14th November 2025

Submission on Ballinlee Wind Power Plant (An Coimisiún Pleanála Ref. PAX91.323780)

Project: Ballinlee Wind Power Plant

Figure 3-12: Final Site Layout

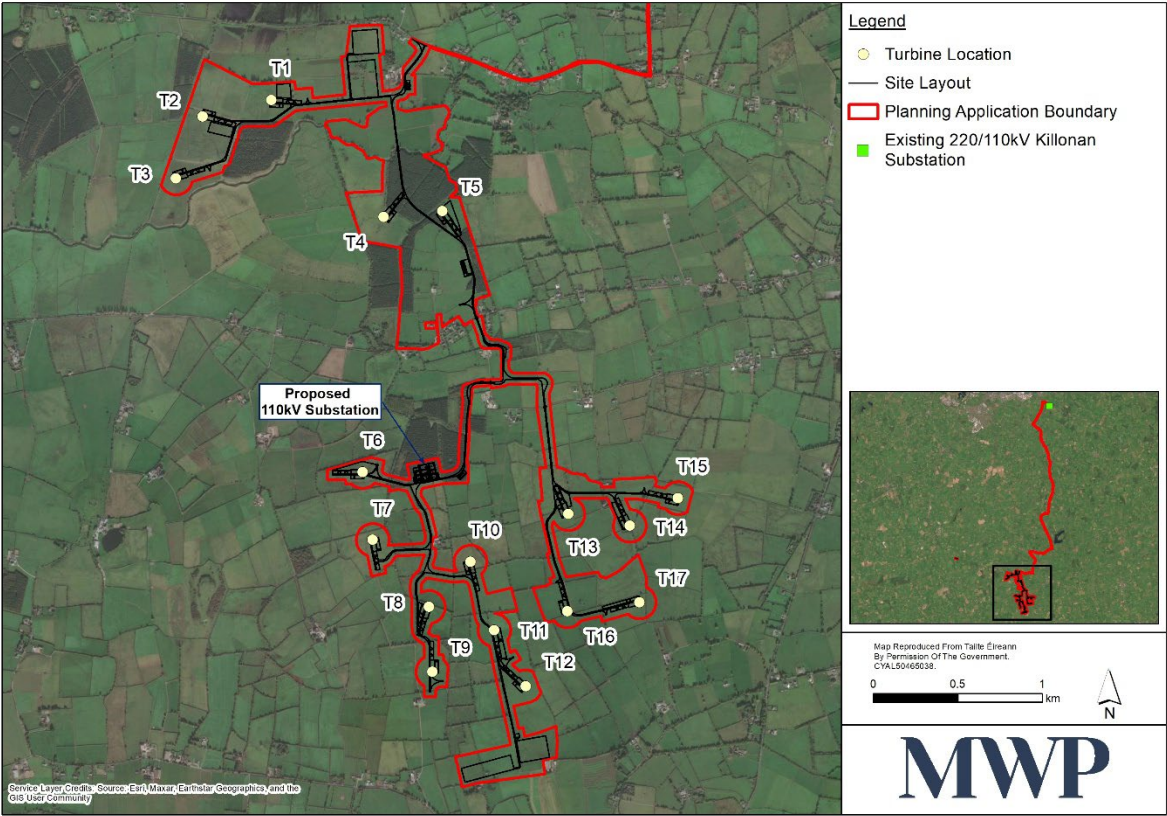
Wind Turbines T1, T2, T3, T5, T6, T9, and T15 are all less than two rotor blades from adjoining property boundaries.

Adjoining Boundary Folio No.	Turbine	Distance	Unit
LK13481	T1	110	m
LK4858	T2	110	m
LK7387F	T2	130	m
LK12589	T3	88	m
LK7387F	T3	82	m
LK1992F	T5	128	m
LK4915F	T6	80	m
LK71	T9	104	m
LK6256	T15	81	m

Consent letters from the above adjoining Folio owners agreeing to a lesser distance of two rotor blades have not been submitted in the applicant submission. It is not clear if consent has been obtained from the adjoining property owners and the applicant failed to submit letters confirming this or if the adjoining landowners are unaware of the proximity of the relevant turbines to their boundary, either way the applicant submission is incomplete and it fails to comply with both the Wind Energy Development Guidelines 2006 and the Draft Revised Wind Energy Development Guidelines December 2019.
